To: El Paso County Board of Directors
El Paso Planning Commission
Re: Mills Timber Subdivision Concerns Regarding Grandwood Ranch Lot F2-15
Date: June 27, 2019

Mills Timber Subdivision has concerns related to the development of lot F2-15 as shown on the Grandwood Ranch Subdivision Preliminary Plan Drawings 5/08/19 (current version on EDARP website).

GRANDWOOD RANCH PRELIMINARY PLAN

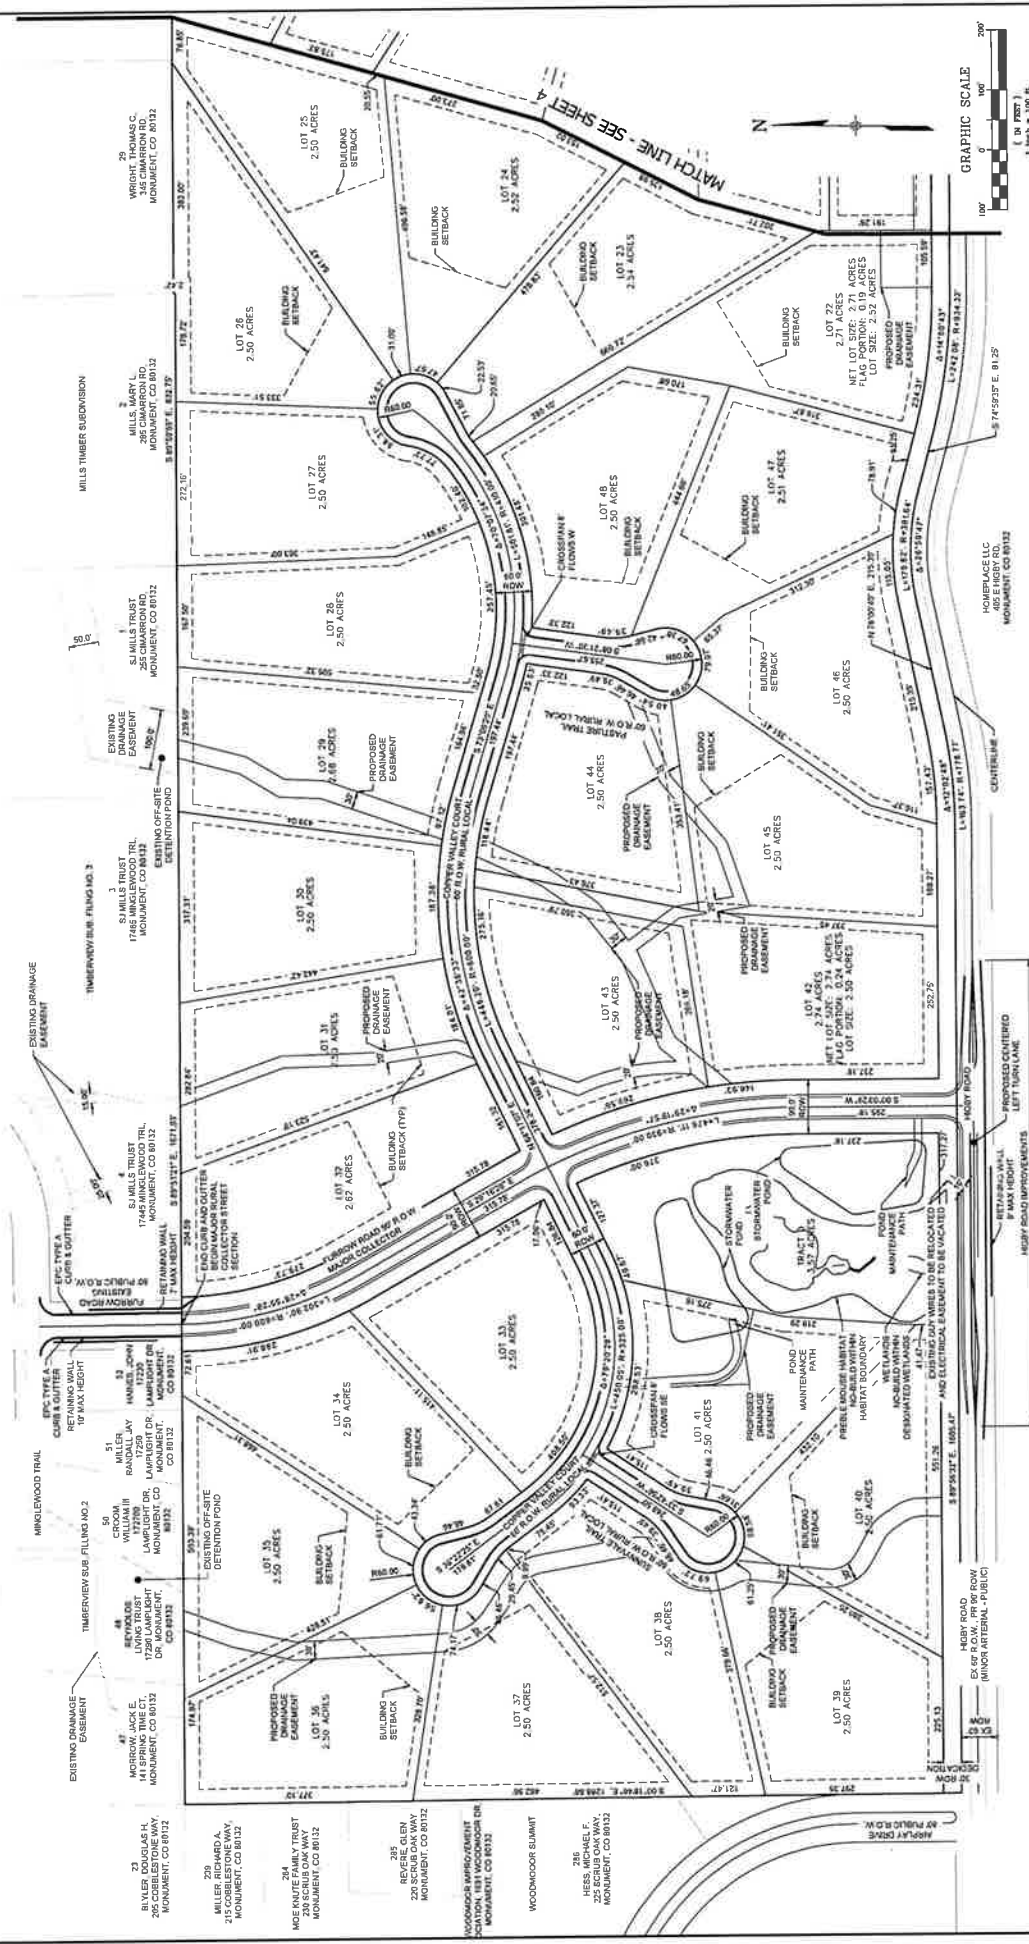
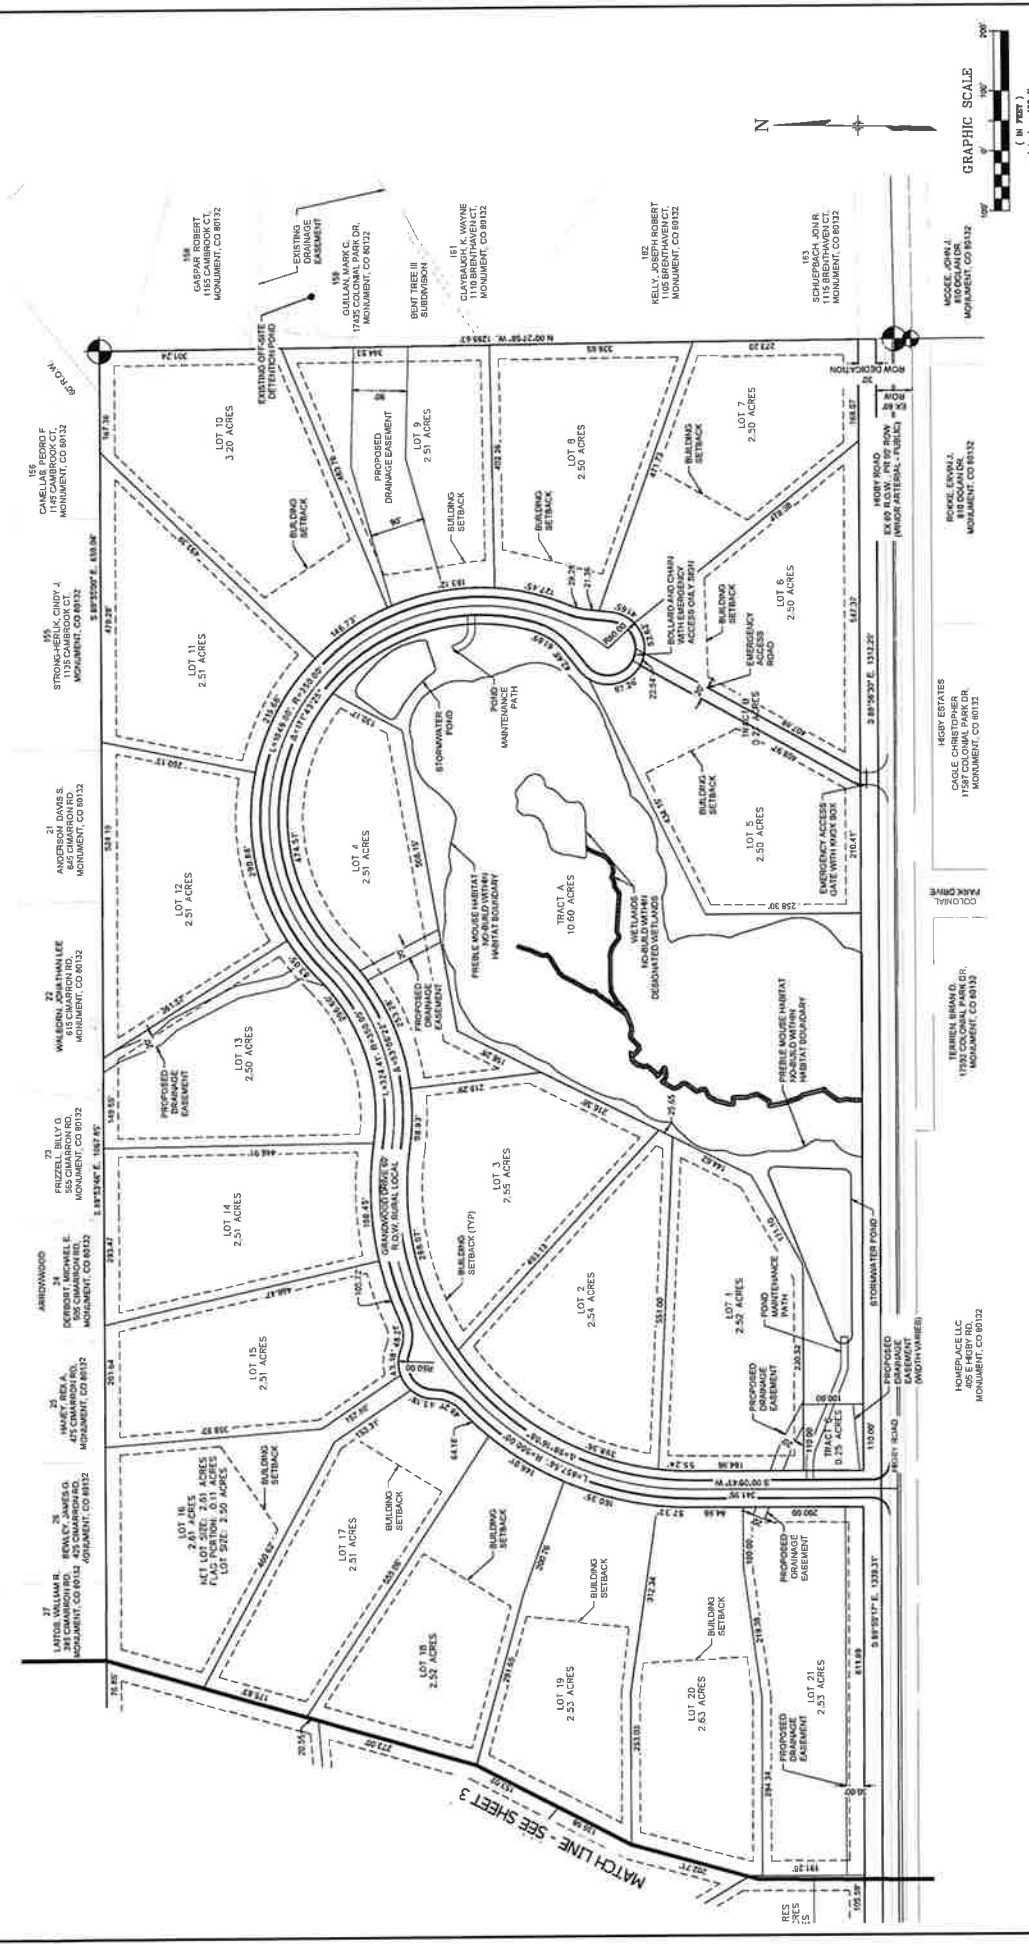
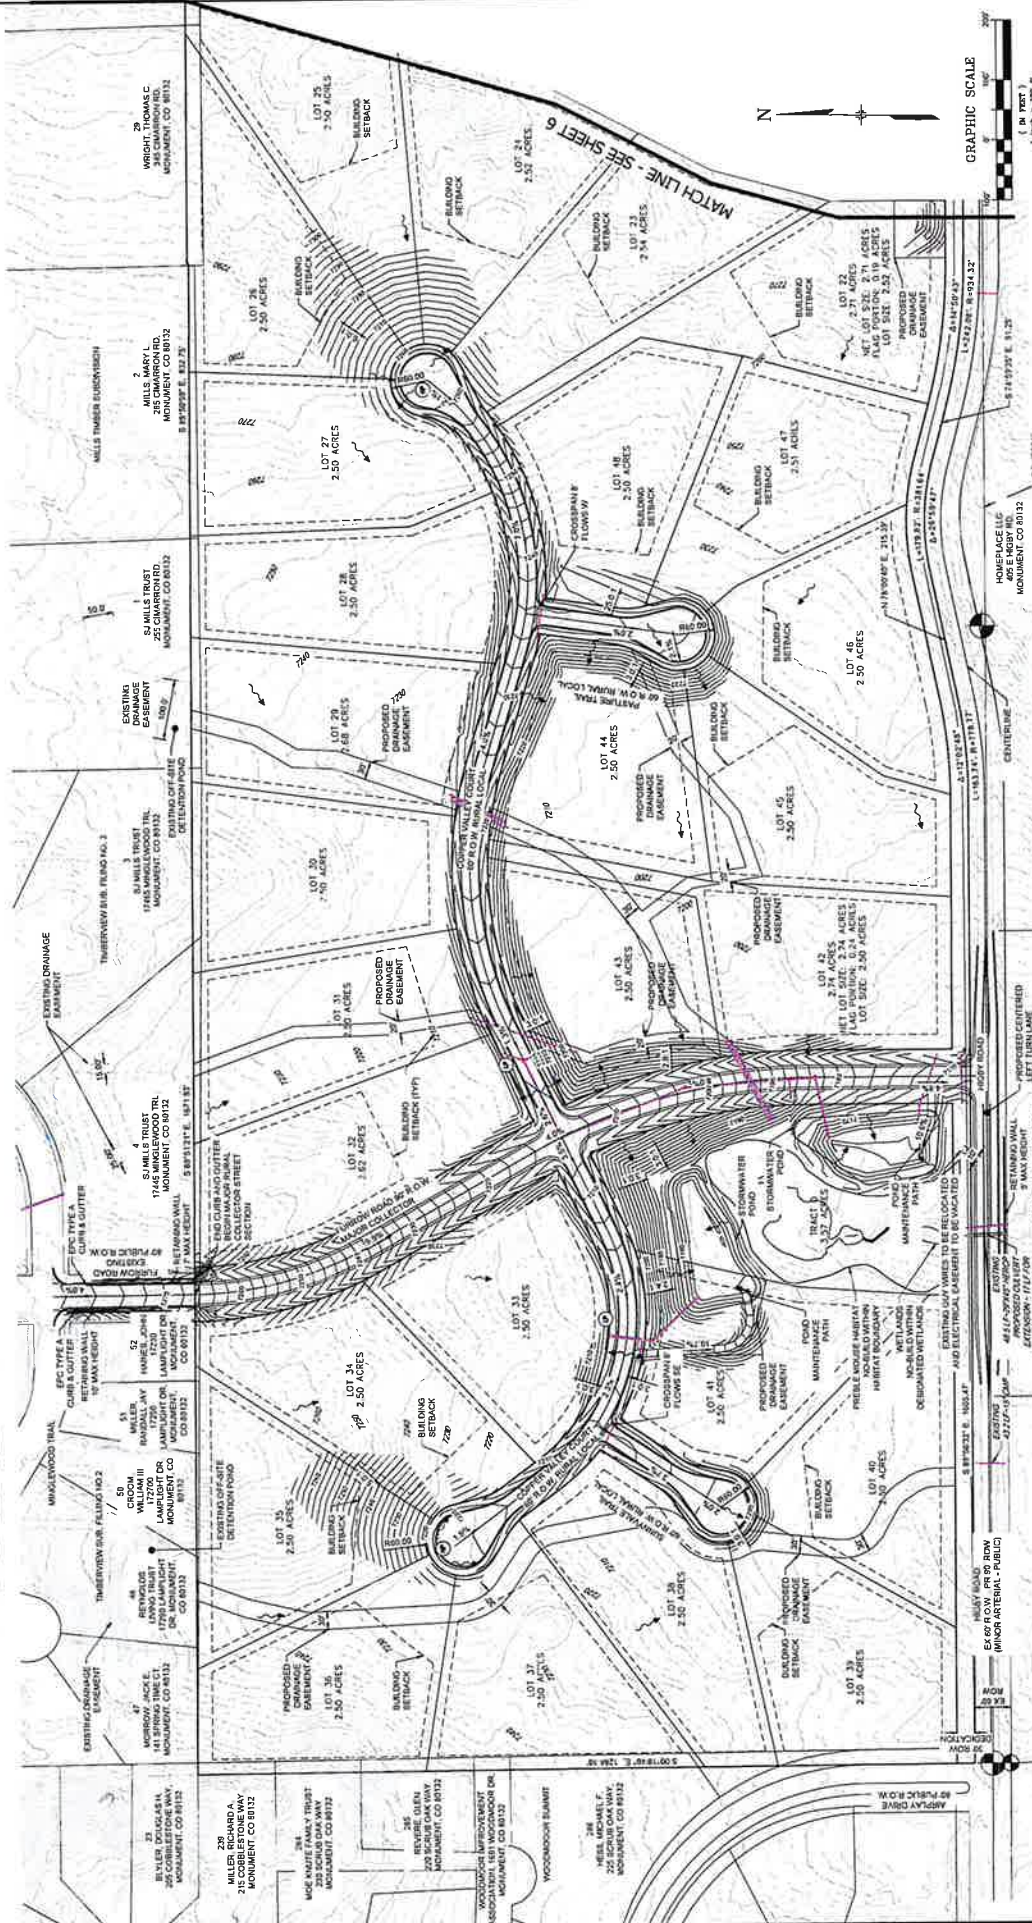
Mills Timber Lot 1 has a pond with constant drainage flow onto Grandwood Ranch Lot F2-15. (See Figure A) A drainage easement is shown on Mills Timber Lot 1, but no drainage easement is shown on the Grandwood Ranch Preliminary Plan Drawings. (Figure B) Given the required leach field and corresponding home placement suggested on page 17 in the Wastewater Evaluation report (rev. 4/1/19) (Figure C) the residential structure will conflict with the natural waterway (Cherry Creek) when the proper drainage easement is established on Lot F2-15. Please consider that a home cannot be built on lot F2-15 as currently platted without restriction to a natural waterway.

RESPONSE: The drainage report and preliminary plan have been updated to include and account for off-site drainage. This includes the addition of no-build drainage easements on several lots.

Grandwood Ranch Submittal Plat 02.28.2019

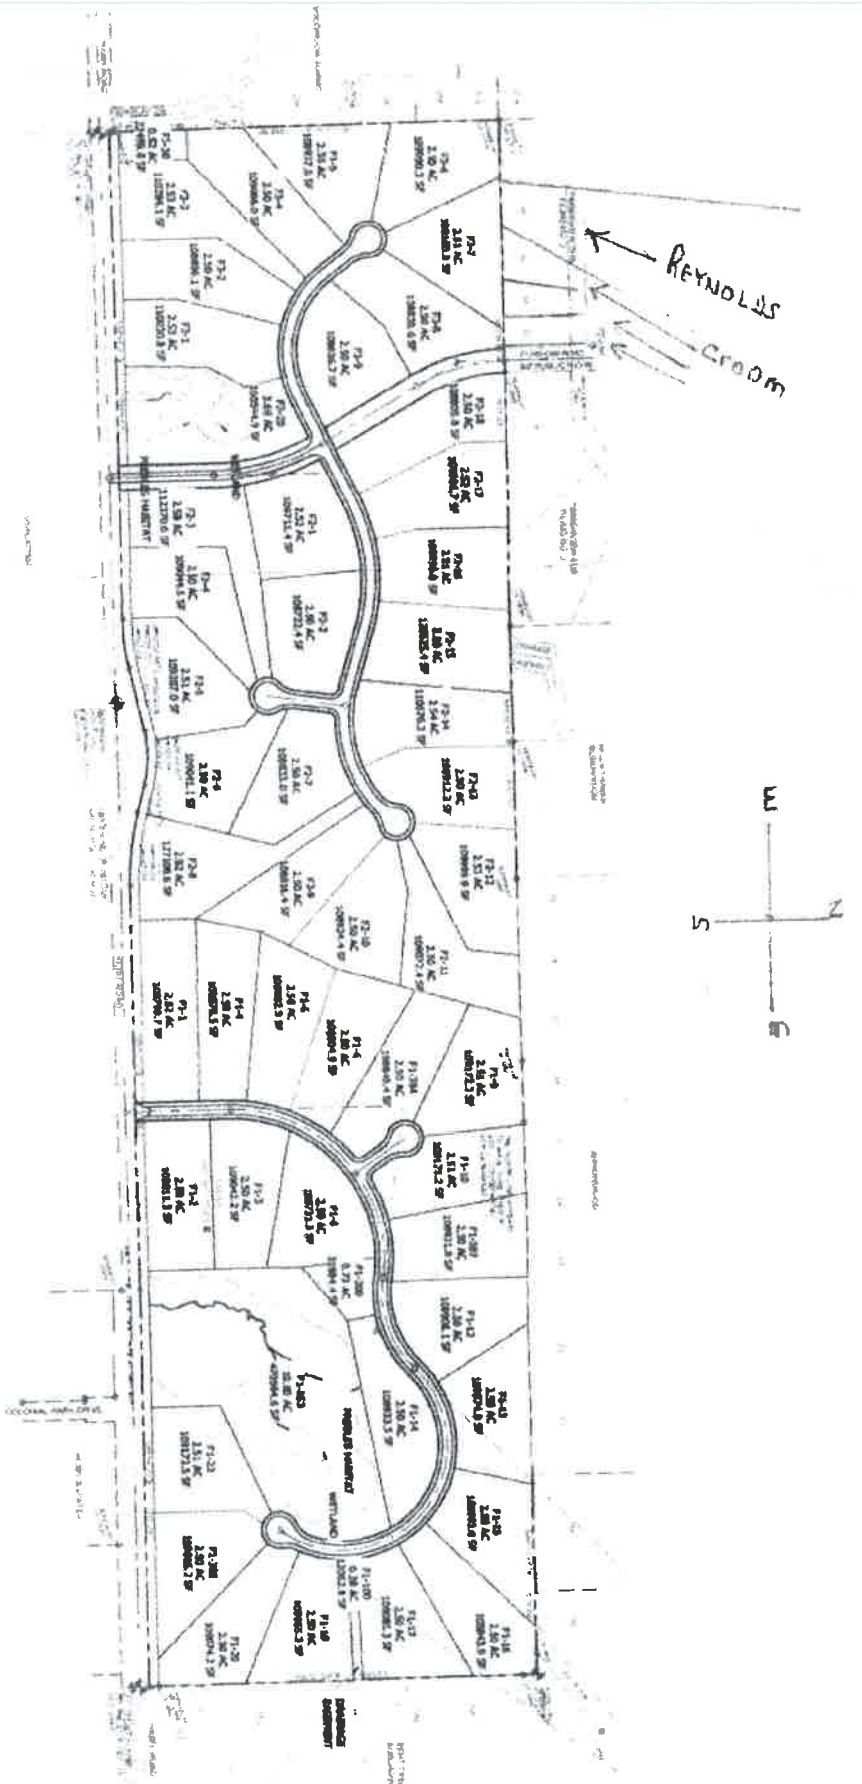
Grandwood Ranch Lot F2-15 may still have area designated as a Preble Mouse habitat. When Mills Timber Lot 1 was developed, the area in question was designated as Preble Mouse habitat area and it is assumed that is still the case. The water entering lot F2-15 is above and connected to the designated Drainage 1 Wetlands and Preble habitat area in the southwestern part of the Grandwood property in the Wetlands Report dated January 10, 2019. (Figure D)

RESPONSE: All wetland and mouse habitat areas have been identified in the Natural Resources Assessment completed by ERO dated January 20, 2019. There are no impacts to these areas and they have been identified as no-build areas on the preliminary plan.
